BAYSIDE COUNCIL SUBMISSION SSD-9691 – ORICA SOUTHLANDS WAREHOUSE ESTATE

Council's Submission on SSD-9691

Council understands that consent for the following development is now sought:

'A warehouse and distribution facility including the construction of two warehouse buildings, ancillary office space and hardstand/car parking areas on an elevated concrete platform above the flood storage area.'

-

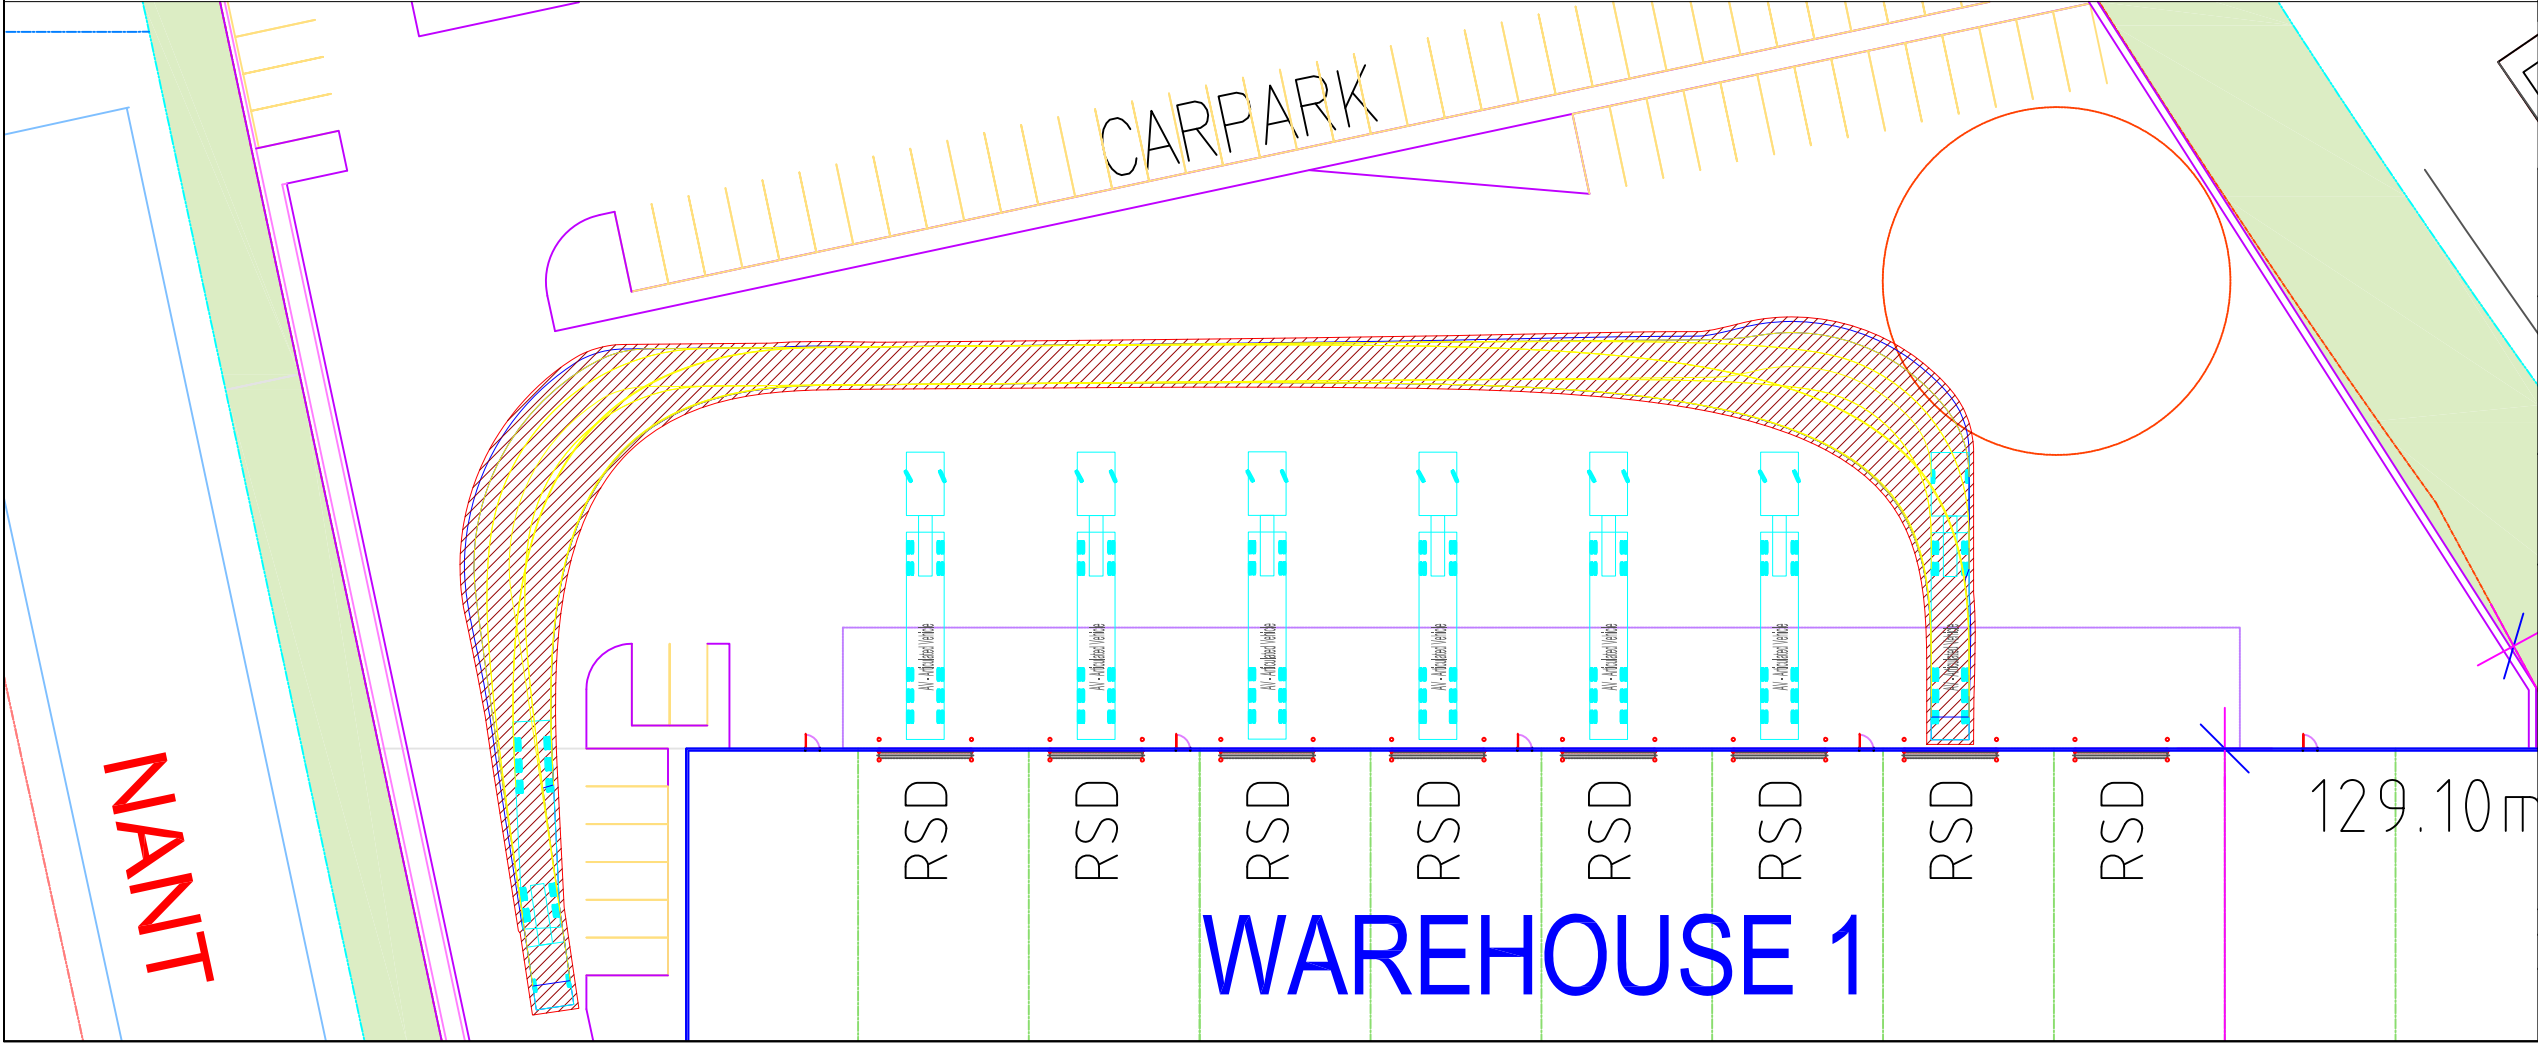
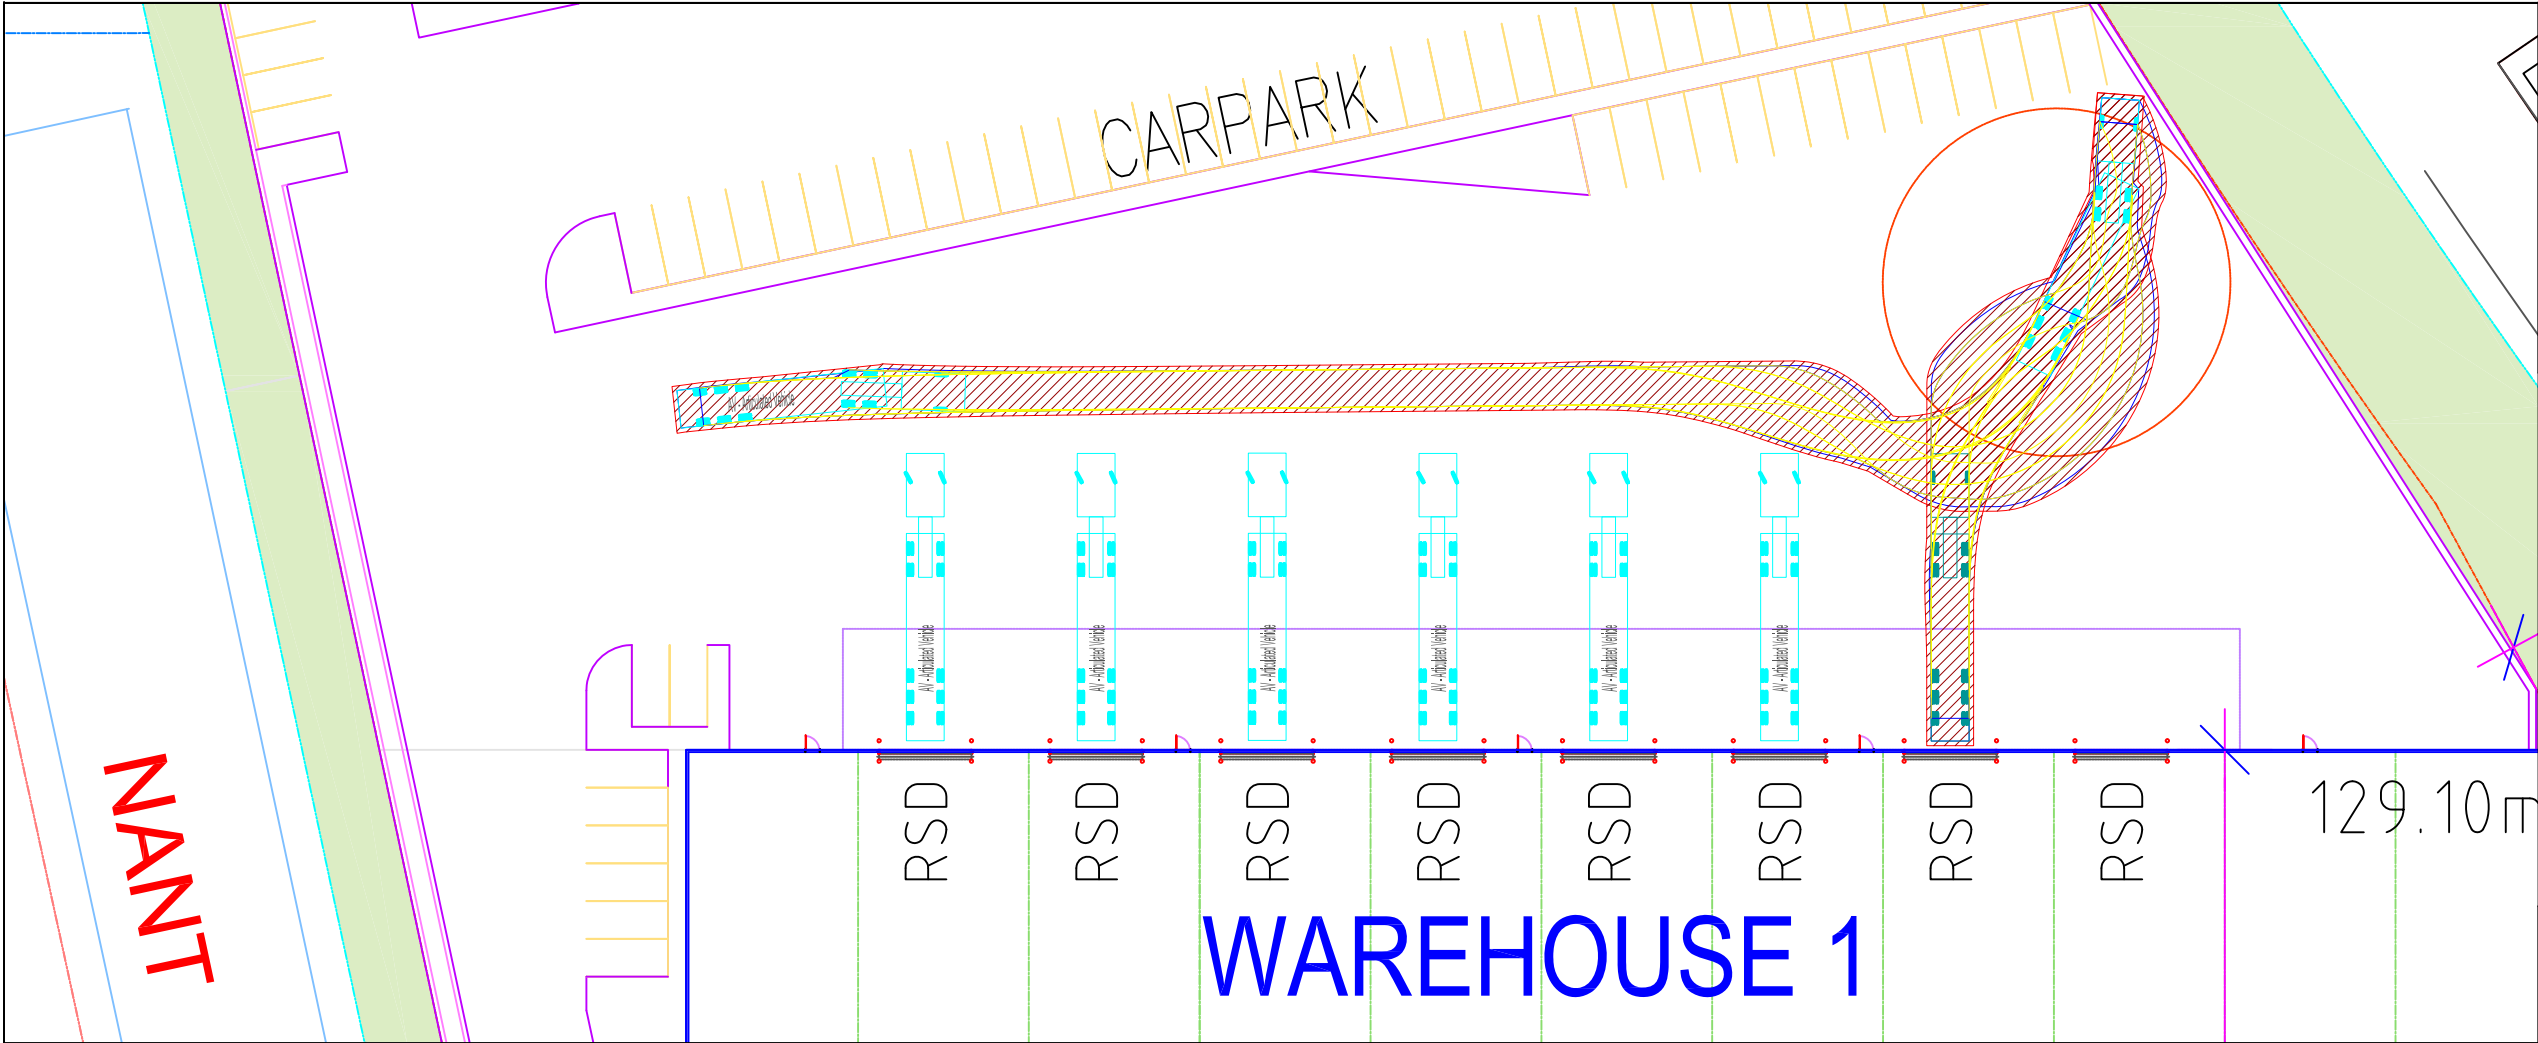
- The access width of 8 metres appears to only narrowly accommodate the B-doubles entry and exit and should be about 12.5m at least, as per AS2890.2;
- The applicant should be requested to provide a secondary access driveway or demonstrate the queuing in and out can be accommodated in a combined driveway;

- Swept paths need to detail how two truck vehicles driving in opposing directions can enter and exit the site simultaneously through the driveway;
- The western car park adjacent to the proposed Warehouse 1 is also within close proximity of the swept paths of B-doubles. Whilst there is no issue with the current arrangement, issues may arise if they intersect with the parking spaces and/or structures;

**STORMWATER KEY PLAN**
1:500

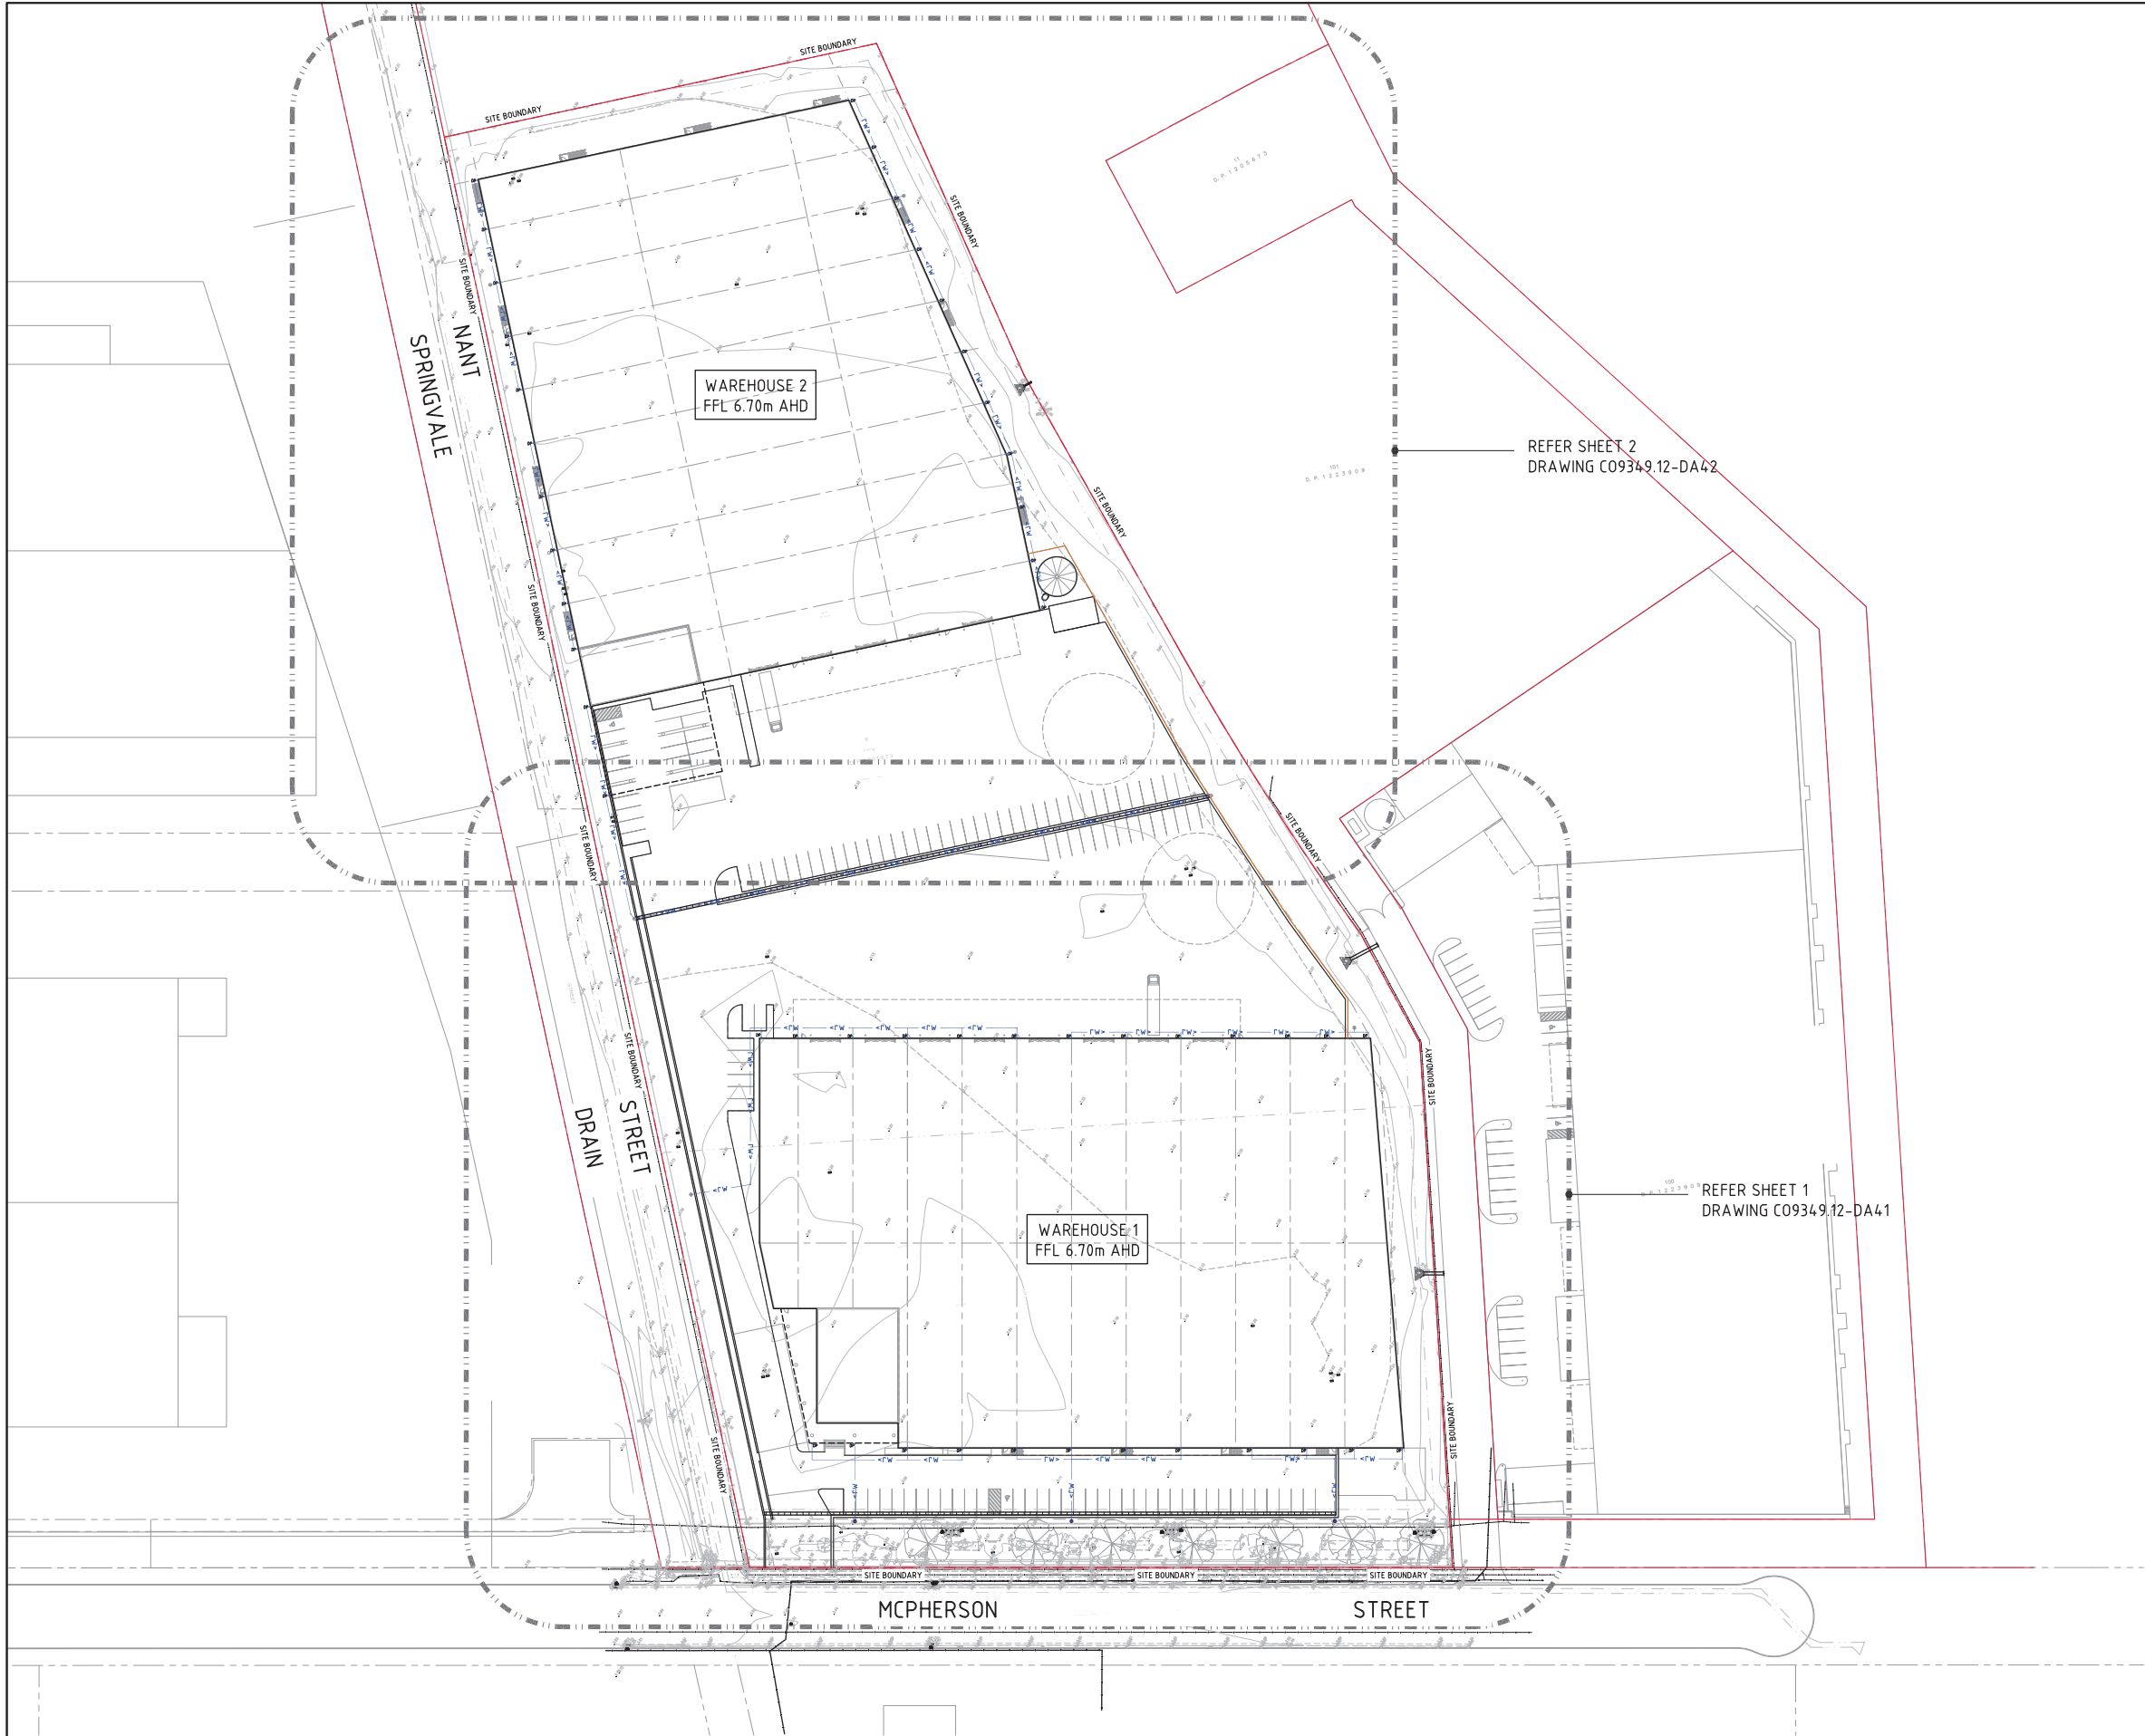
- The locations and specifications of water quality treatment devices need to be shown on the civil engineering plans; and
 - The MUSIC model should use the latest available rainfall data. Section 7.3.2 of the Civil Engineering Report states the MUSIC modelling has relied on the rainfall data from the 1962 to 1966 period.

- Stormwater Management:
 - More details are needed for the ground floor slab drainage. An even distribution of drainage flow across the site into the storage basin below is required. Concentrated discharges are not supported from the ground floor slab into the basin.
